Our Ref: CM/43/21/DOC

Approval of details reserved by condition imposed under CM/16/21/PL relating to conditions 6-details of proposed grease trap/separator, 7-extraction details & 8-boundary treatments to southern & western boundary.

Bairds Farm Shop Crookthorn Lane Climping BN17 5SN

Arun District Council have decided to **REFUSE details reserved by condition for the following reasons:**

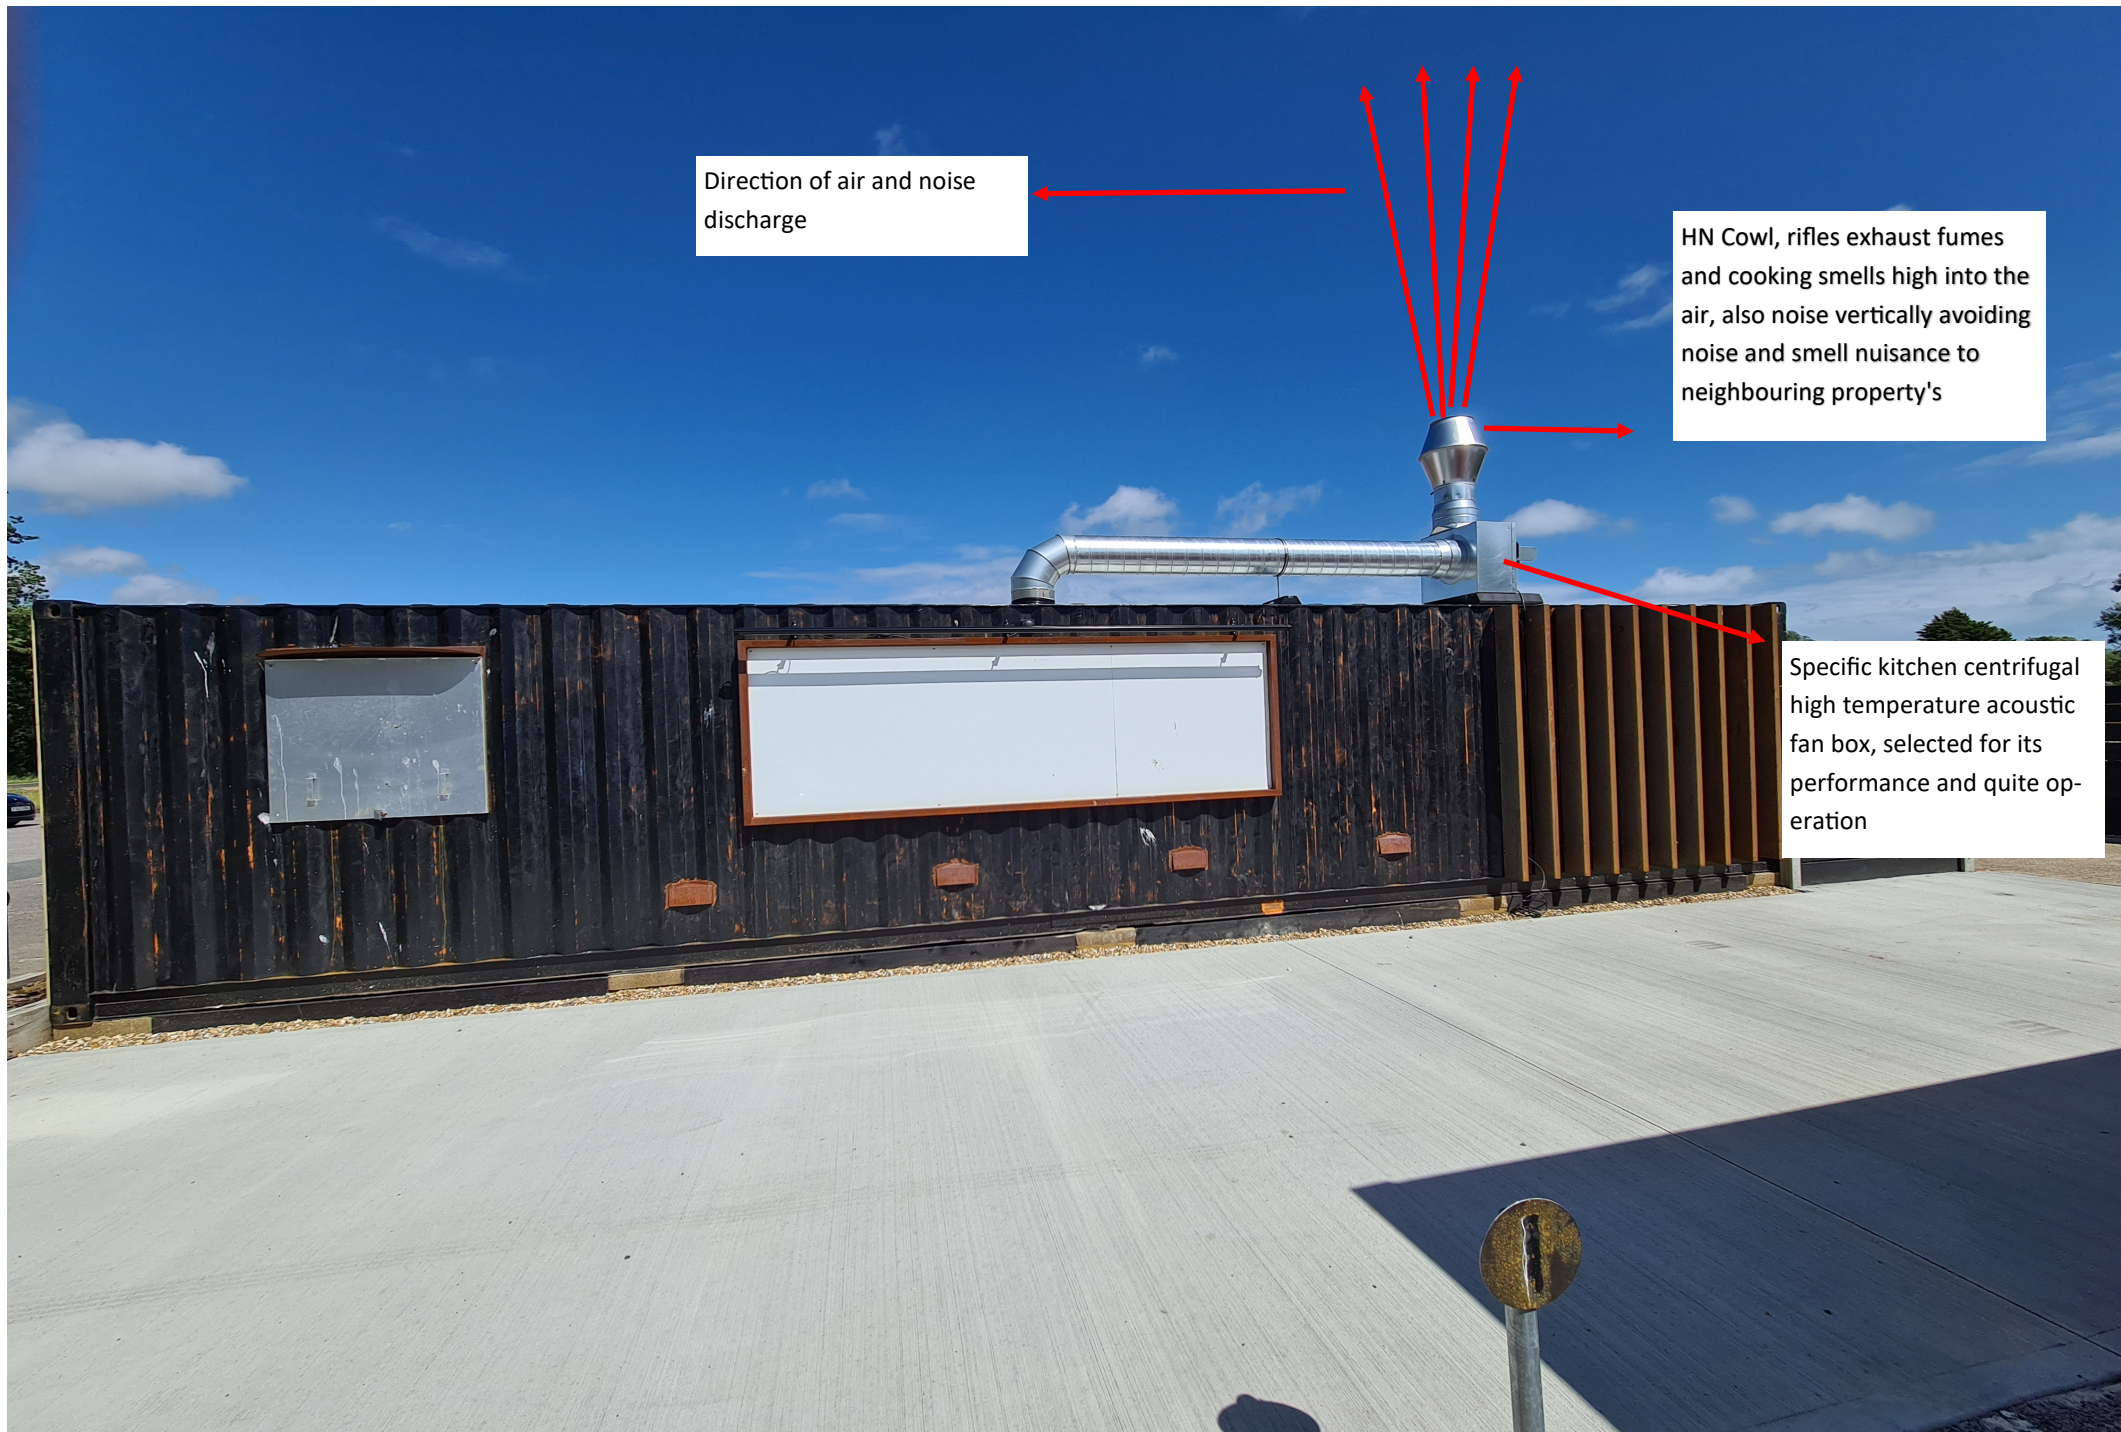
This condition cannot be discharged at this time. Having reviewed the document entitled 'Ventilation / extraction statement' it is noted the applicant proposes to use a grease filter, followed by carbon activated pre-filters and fine filters fitted between the grease filter and fan. The Emaq guidance advises that carbon adsorption filters with a residence time of 0.1 - 0.2 seconds would be required for medium level odour control. It is unclear from the information provided as to the size of kitchen (number of covers per day) and the type of food that will be cooked on site.

The details of the equipment submitted are also considered to be visually obtrusive and the proposal should include some form of screening. This may require an application for planning permission in its own right.

To overcome this objection it will be necessary for the applicant to perform the odour control risk assessment included in the EMAQ guidance to demonstrate that adequate odour control has been installed. Further information should be provided to demonstrate the carbon filter residence time advised by the risk assessment can be provided by the proposed extraction system.
